CITY OF ALBUQUERQUE

October 3, 2019

**RE: Springstone Parking Lot and Garage
Davenport St NW
Grading Plan Stamp Date: 9/18/19
Drainage Report Stamp Date: 9/18/19
Hydrology File: C12D003B2**

SPRINGSTONE PARKING LOT AND GARAGE GRADING & DRAINAGE PLAN

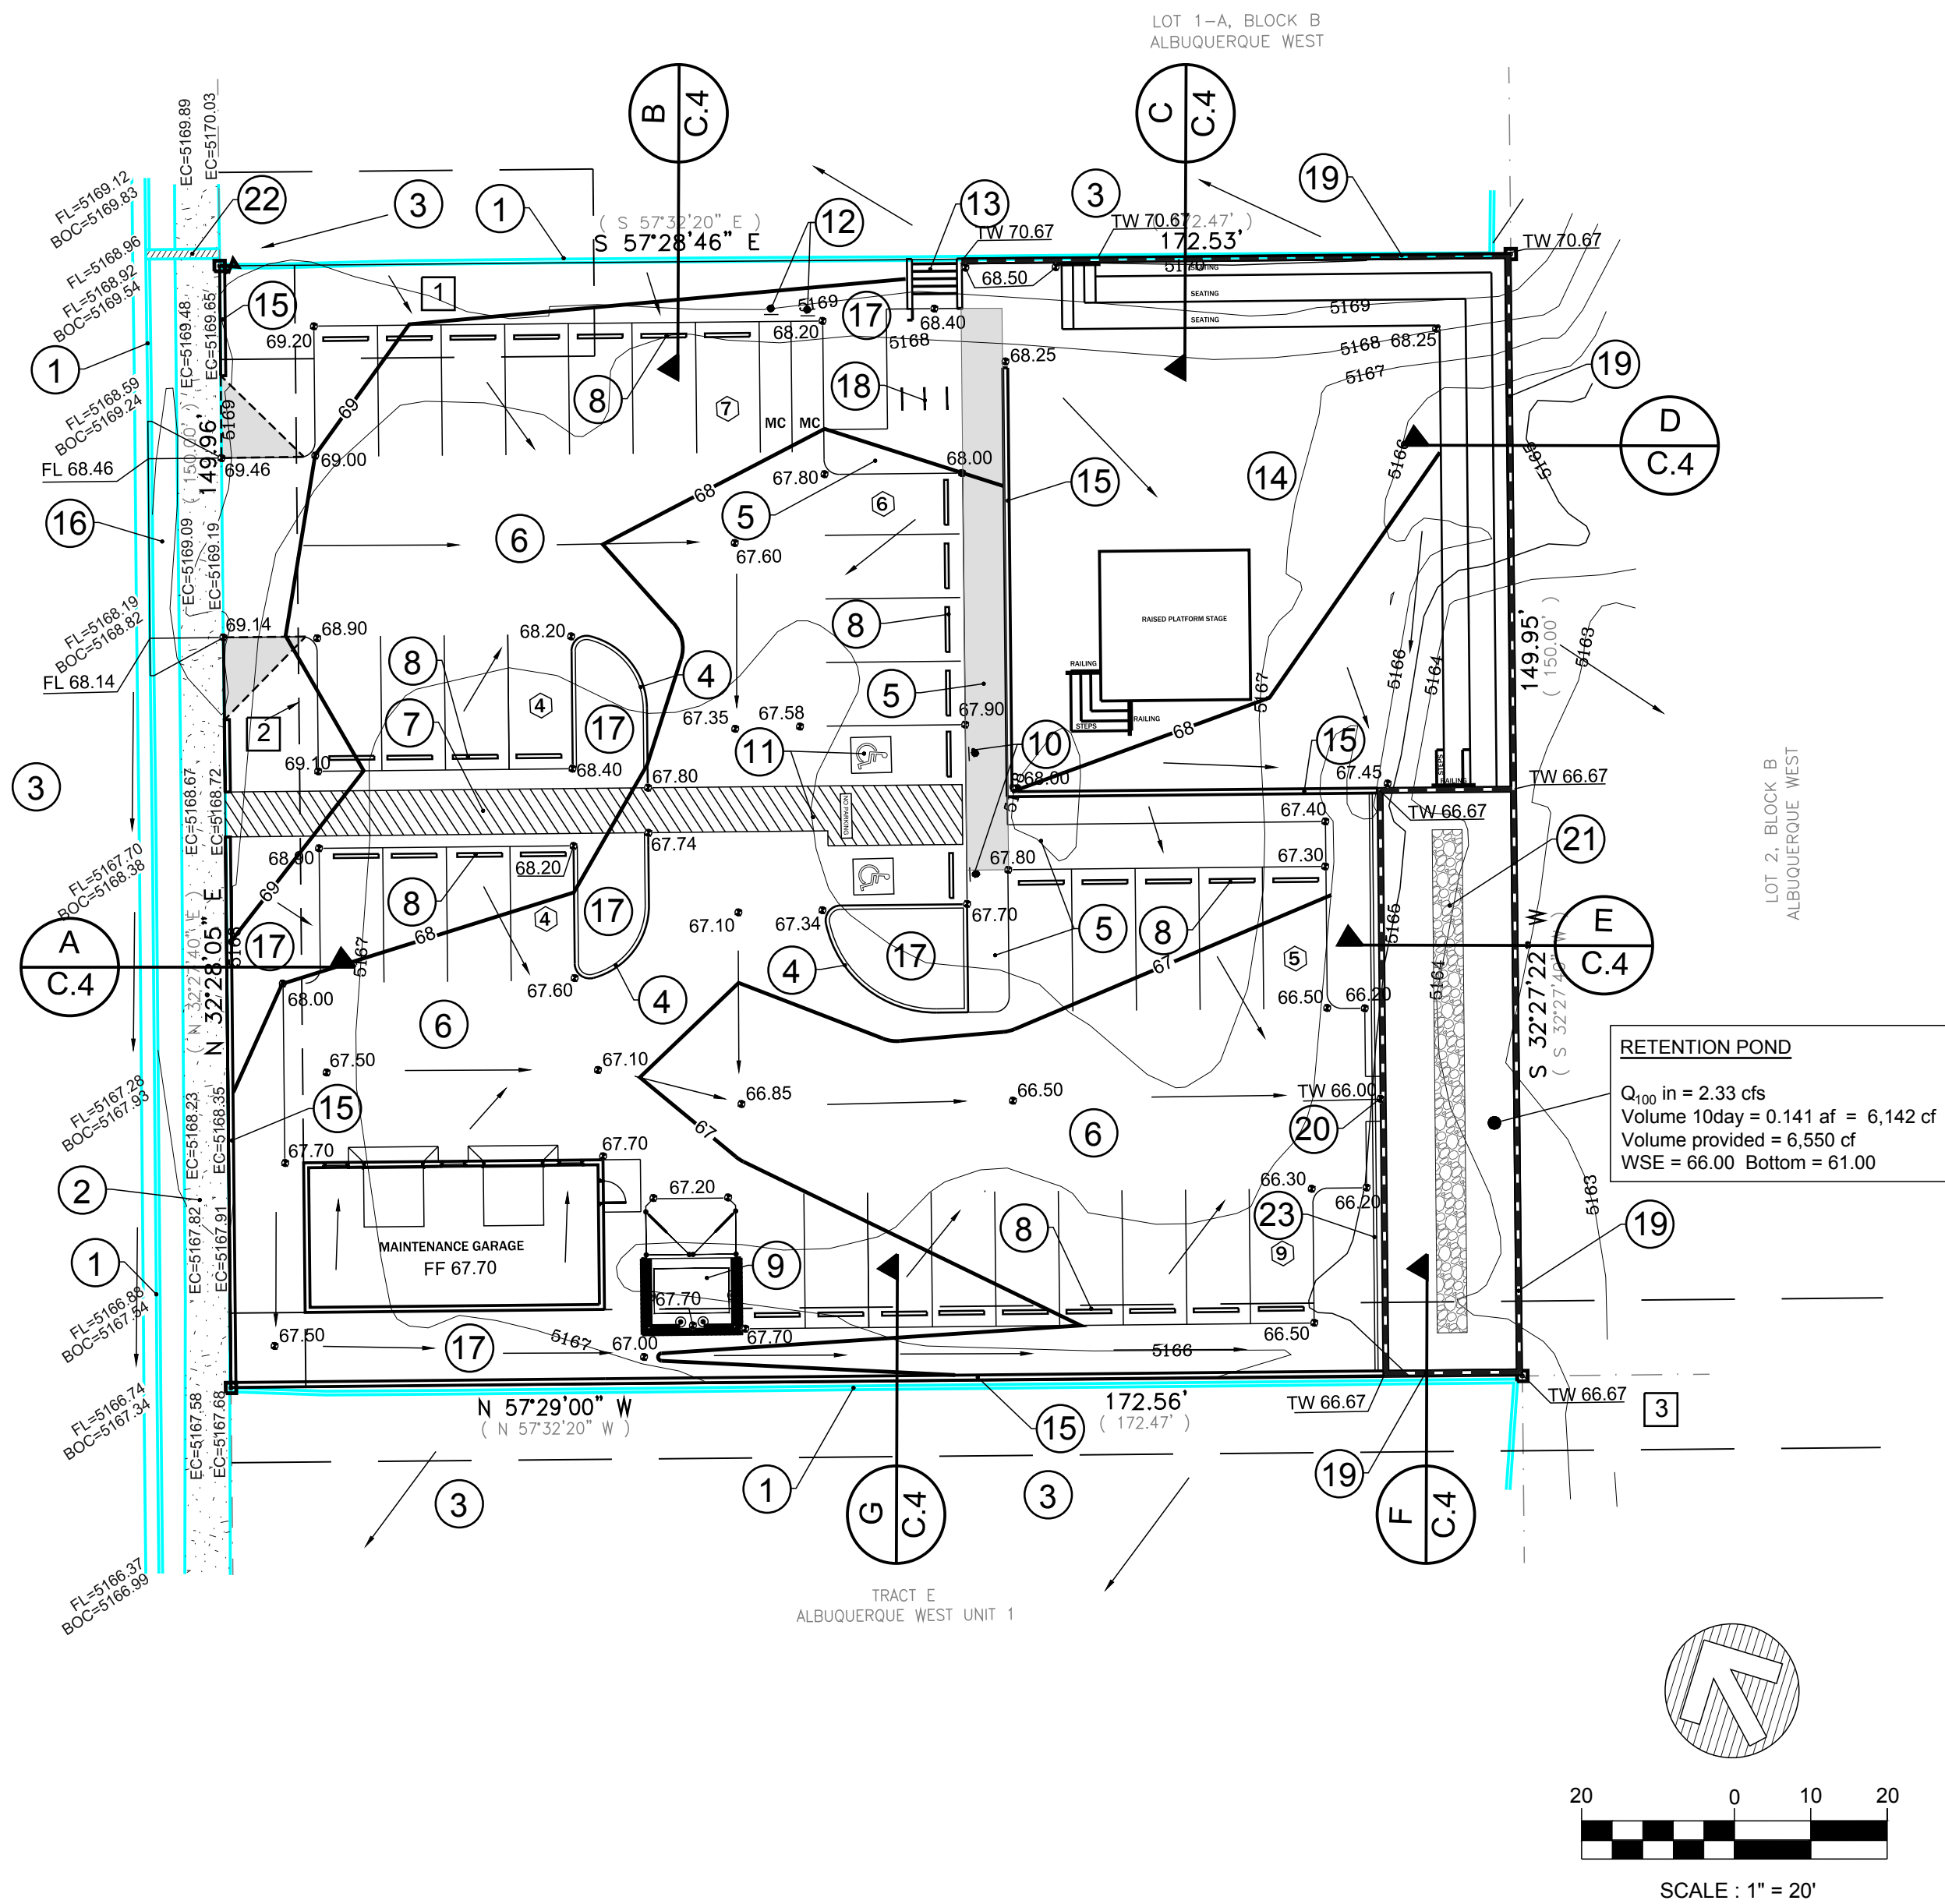
1. This site must comply with the City-approved Drainage Master Plan for Fountain Hills (BHI, 2007, C12D003). This DMP shows this site and the Springstone site directly north as discharging to Davenport at a rate of 8.06cfs (aggregated).

2. As an alternative, you could provide onsite 100-yr, 10-day retention ponding, or obtain an easement to discharge across the carwash and out to Education Pl.

3. Please provide the street address.
4. Any work proposed on other's property, must include written and signed permission from that property owner.
5. Provide sections through the external boundaries showing proposed slopes, retaining walls, garden walls, property/ROW lines, existing and proposed grades. In accordance with DPM Ch.22, section 5 part B, grading and wall construction near the property line may not endanger adjacent property or constrain its use.

6. With AHYMO S4, be sure to use NOAA Atlas 14 precipitation depths in conjunction with the NOAA Atlas 14 distribution. Include the location map and tables obtained from the NOAA website. Using the NOAA Atlas 2 Precipitation depths (Found in the DPM), with the NOAA Atlas 14 Distributions results in an over-prediction of peak runoff (Q_{100}).

7. Include project benchmark and datum; all existing survey, proposed grades, and benchmarks must be provided in NAVD 88.
8. As a reminder, if the project total area of disturbance (including the staging area and any work within the adjacent Right-of-Way) is 1 acre or more, then an Erosion and Sediment Control (ESC) Plan and Owner's certified Notice of Intent (NOI) is required to be submitted to the Stormwater Quality Engineer (Doug Hughes, PE, jhughes@cabq.gov, 924-3420) 14 days prior to any earth disturbance.
